# Heckington Fen Solar Park

## Appendix 8.13 – Biodiversity Net Gain Assessment Report

Document Reference: ExA.6.3.8.13-D2.V1

## BIODIVERSITY NET GAIN ASSESSMENT – REPORT

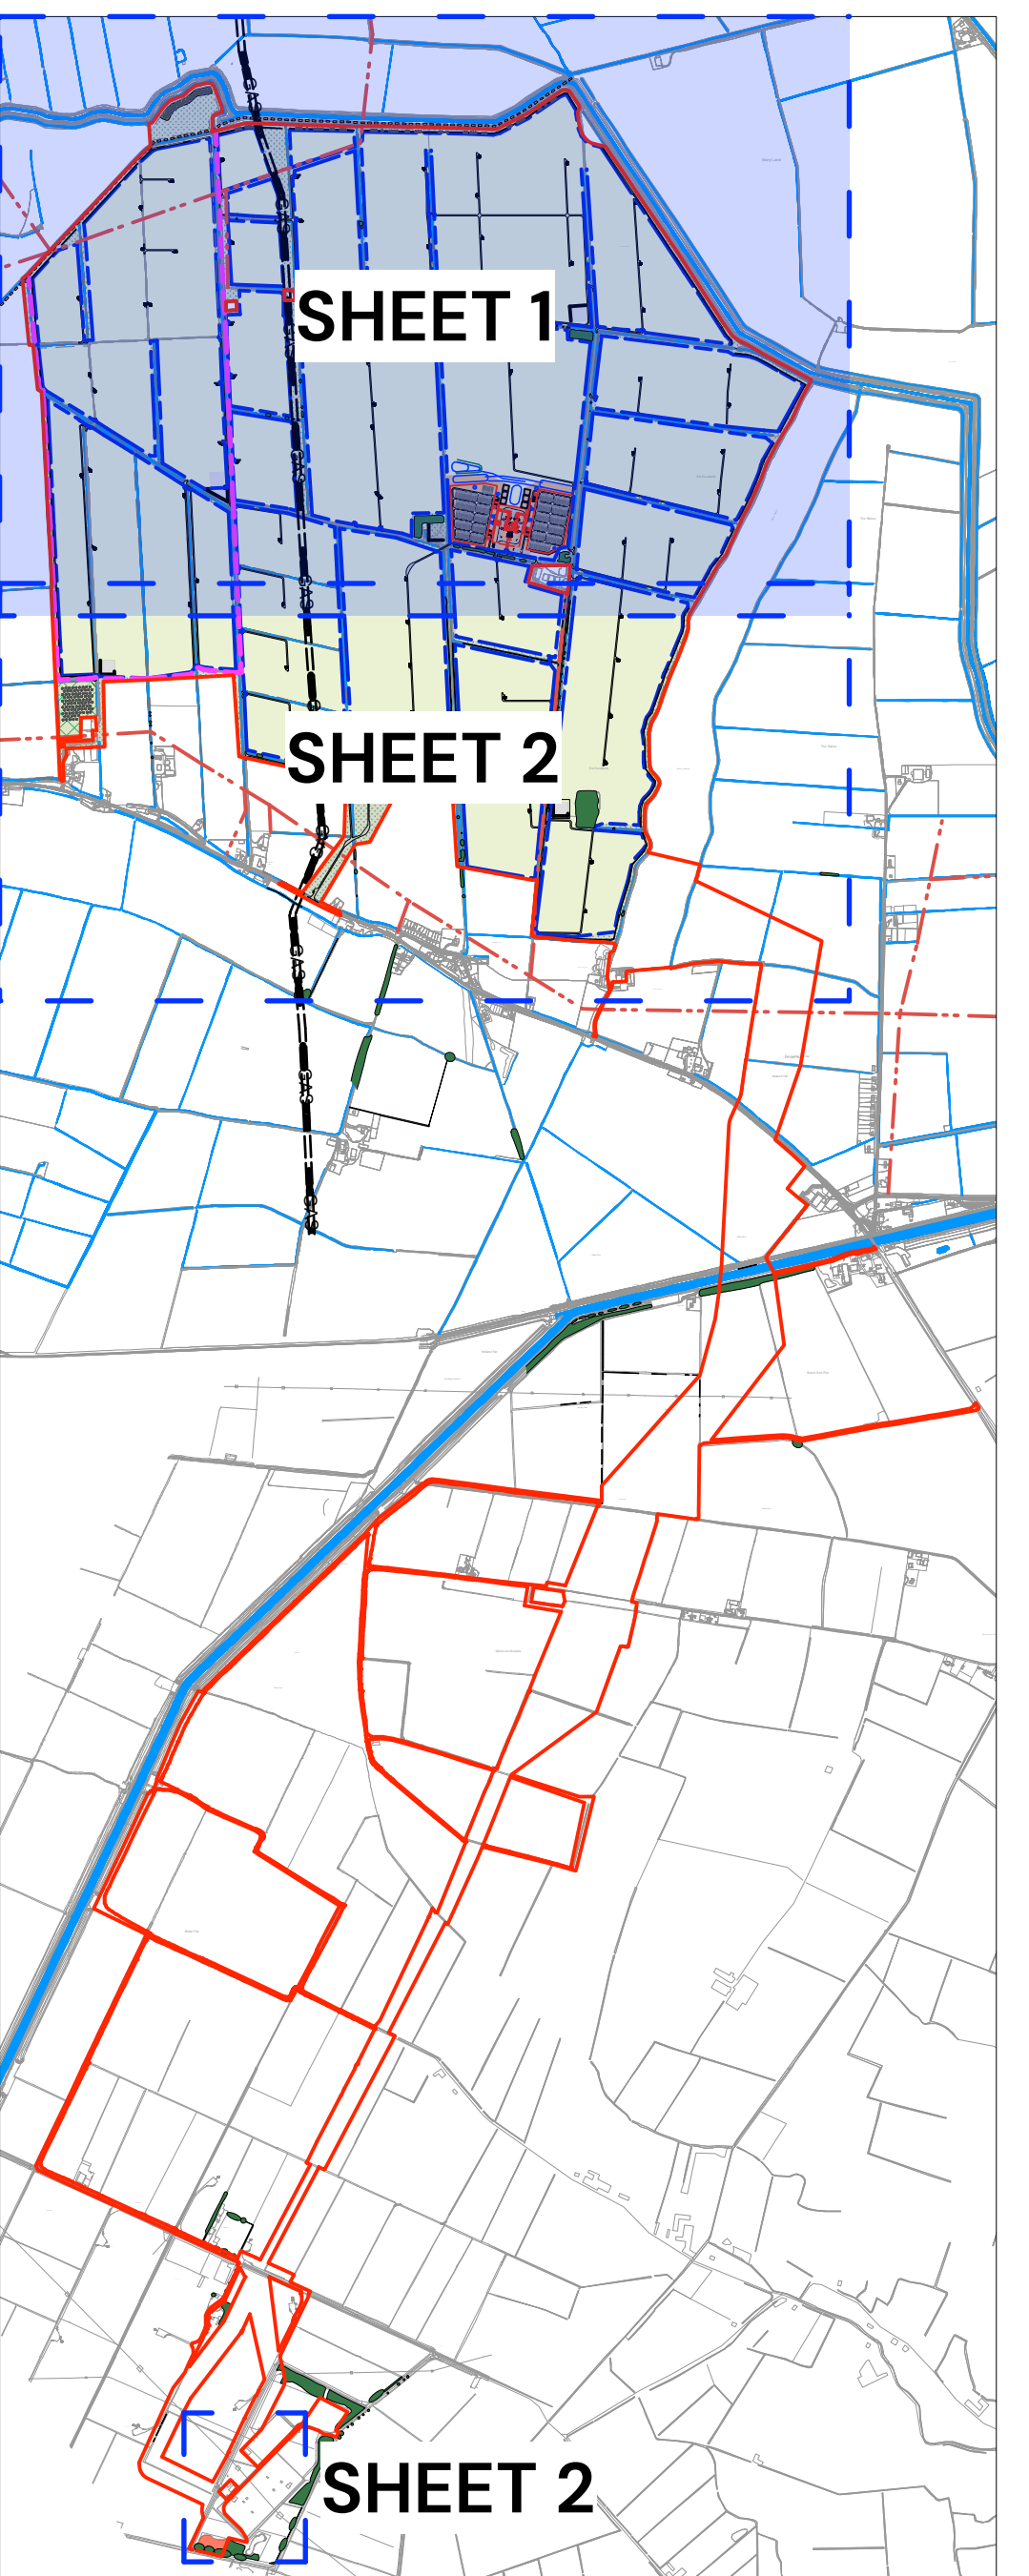
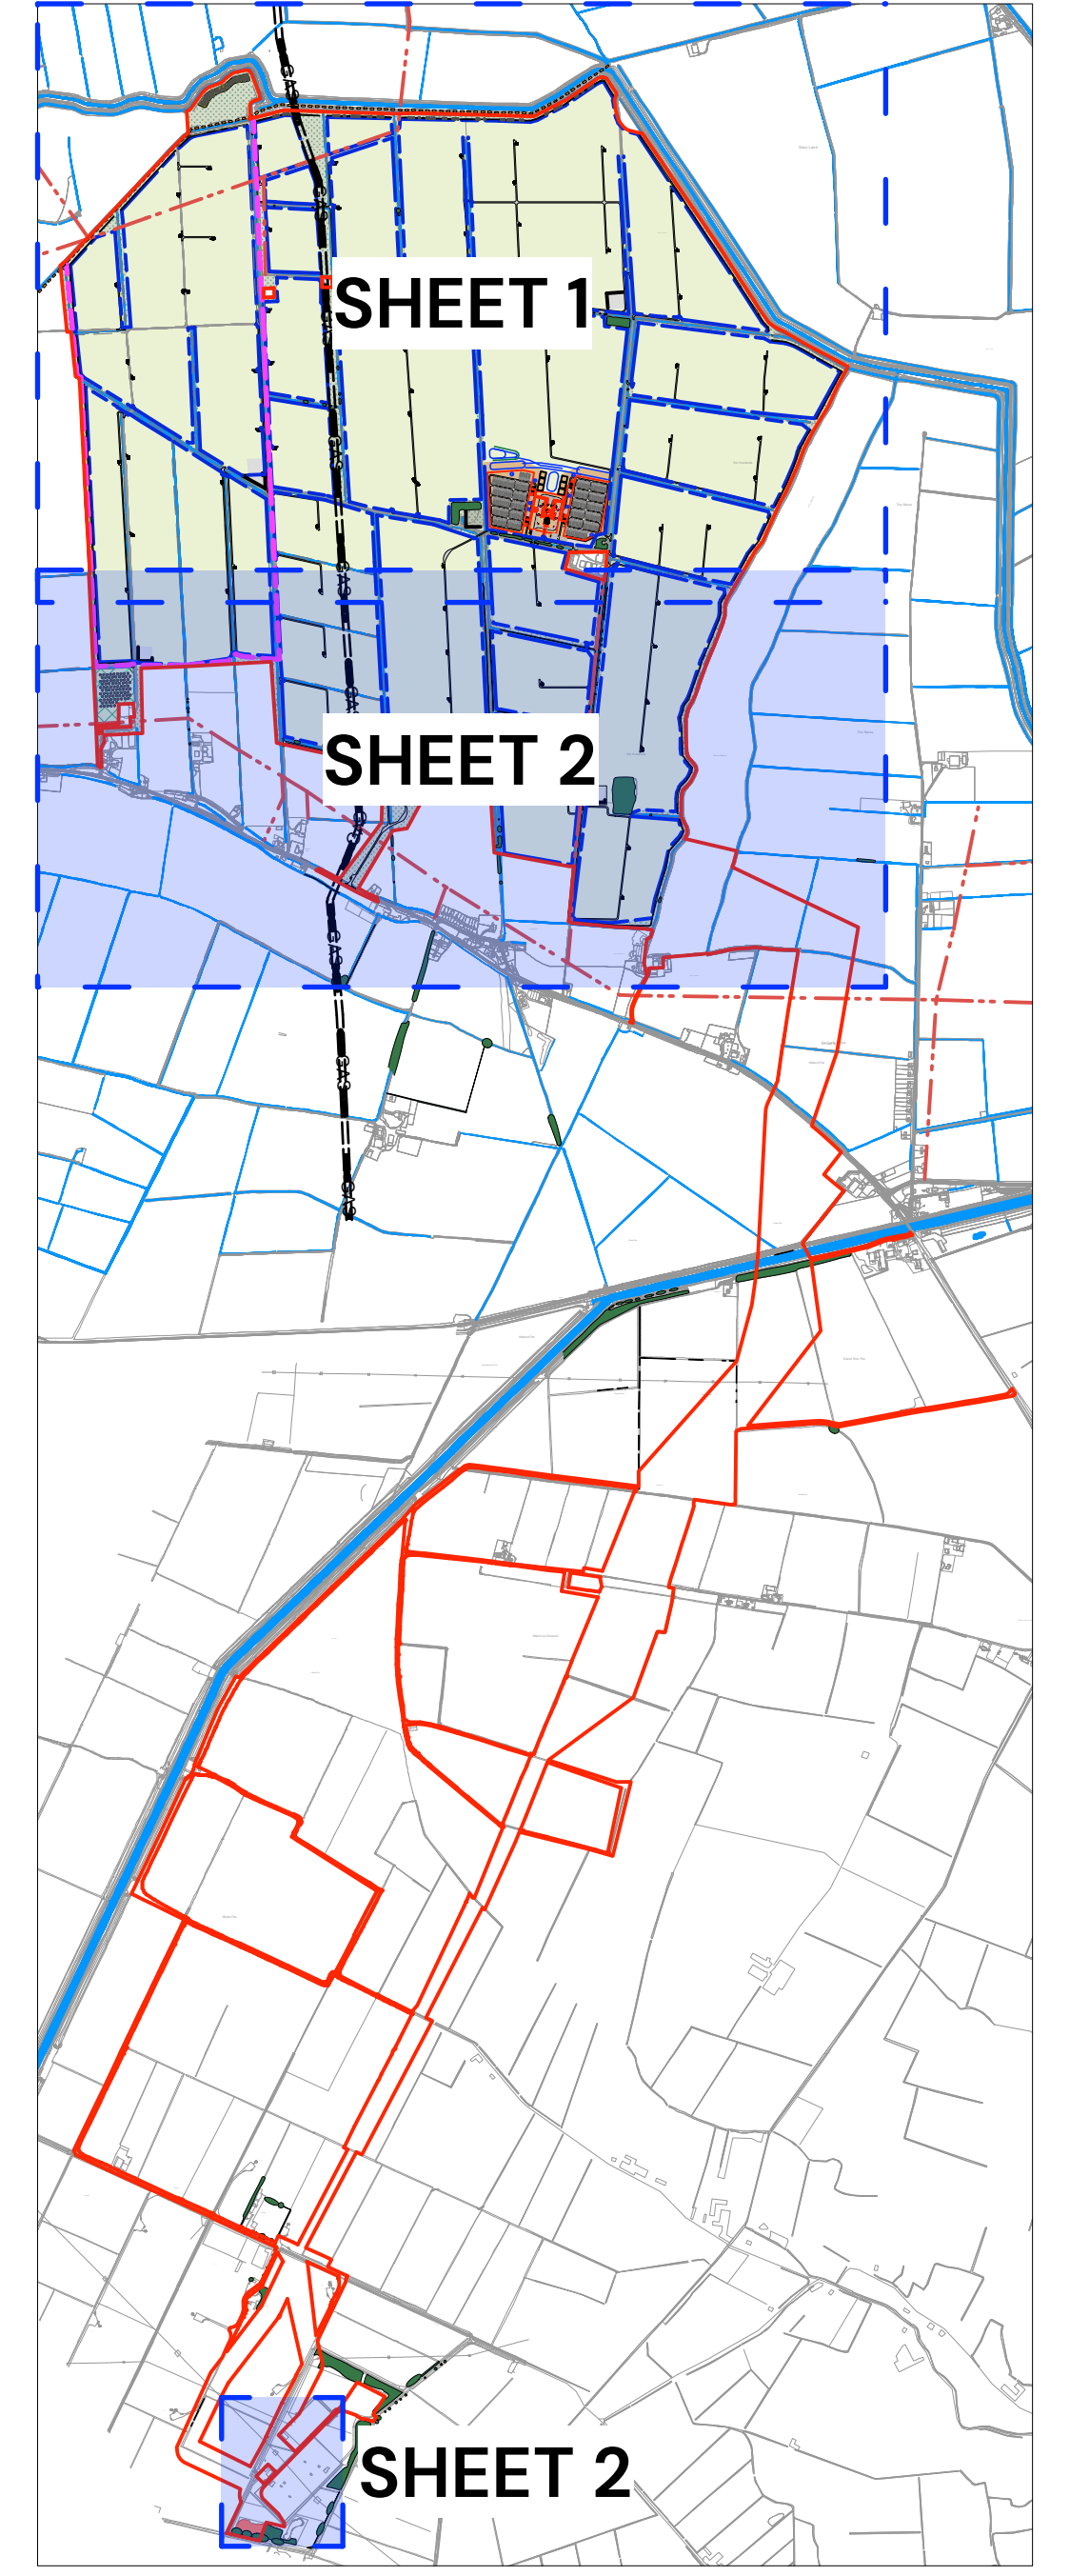
Comment	Response
<p>Landscaping strategy (Documents 6.2.6 and 7.8) cannot be agreed until a complete BNG assessment. This was requested at PEI stage and is otherwise a requirement of the good practice guidance accompanying Metric 3.1. Comparable local guidance has also been published with the Central Lincolnshire Local Plan. All good practice requirements need to be met, and any divergences or use of professional judgement fully explained.</p> <p>The level of detail is sufficient to understand what is being offered in broad terms, but it does not represent a full specification suitable to set terms of reference for agreement of the detailed plan later as a Requirement. The quantum of BNG that can be achieved (while likely to be over 10%) cannot be agreed until sufficient information has been provided to verify the applicant’s BNG calculations.</p>	<p>The submission of this BNG Assessment seeks to address these points.</p>

<p>Details are not provided on the proposed grassland seed mixtures, or how it is intended to create the habitat.</p> <p>It is not clear that this is enhancement rather than habitat creation for BNG assessment purposes.</p> <p>I do not agree that over-sowing of existing grassland headlands alone is likely to be sufficient to establish species rich grassland.</p>	<p>Table 3 in this report lists preferred seed mixes. Seed mixes will be tailored to the site following detailed soil sampling proposed to be undertaken in 2024 and an assessment of the availability of seed stock at the time of habitat creation.</p> <p>The updated metric calculation considers arable reversion to grassland to be ‘habitat creation’ in the metric. A change from the broad habitat type of ‘cropland’ to the broad habitat type of ‘grassland’.</p>

Comment	Response
	<p>Further details relating to habitat enhancement, creation and management are provided in the accompanying CEMP<sup>11</sup> and OLEMP<sup>12</sup>.</p> <p>Section 6.19 of the OLEMP, provides details relating to the grassland establishment phase including measures such as harrowing that will occur prior to the over-sowing of existing headlands.</p>
<p>The plan shows grassland provision where there are existing farm tracks e.g. at the southwest corner. Therefore the extent of grassland provision is likely over-stated.</p>	<p>Mapping has been assessed and all existing and proposed farm tracks are now accounted for within baseline and post development calculations.</p>
<p>The balance between new hedgerow creation and the gapping up of existing hedgerows (which is likely to be enhancement) is unclear. This could have relevance to the calculated BNG.</p>	<p>The balance between the sites baseline hedgerows and the proportions of those to be retained, enhanced or created is set out in this report and accompanying metric.</p> <p>All existing hedgerows (c.6km) will be retained and enhanced.</p> <p>An additional c.8.5km of new hedgerow will be created.</p>
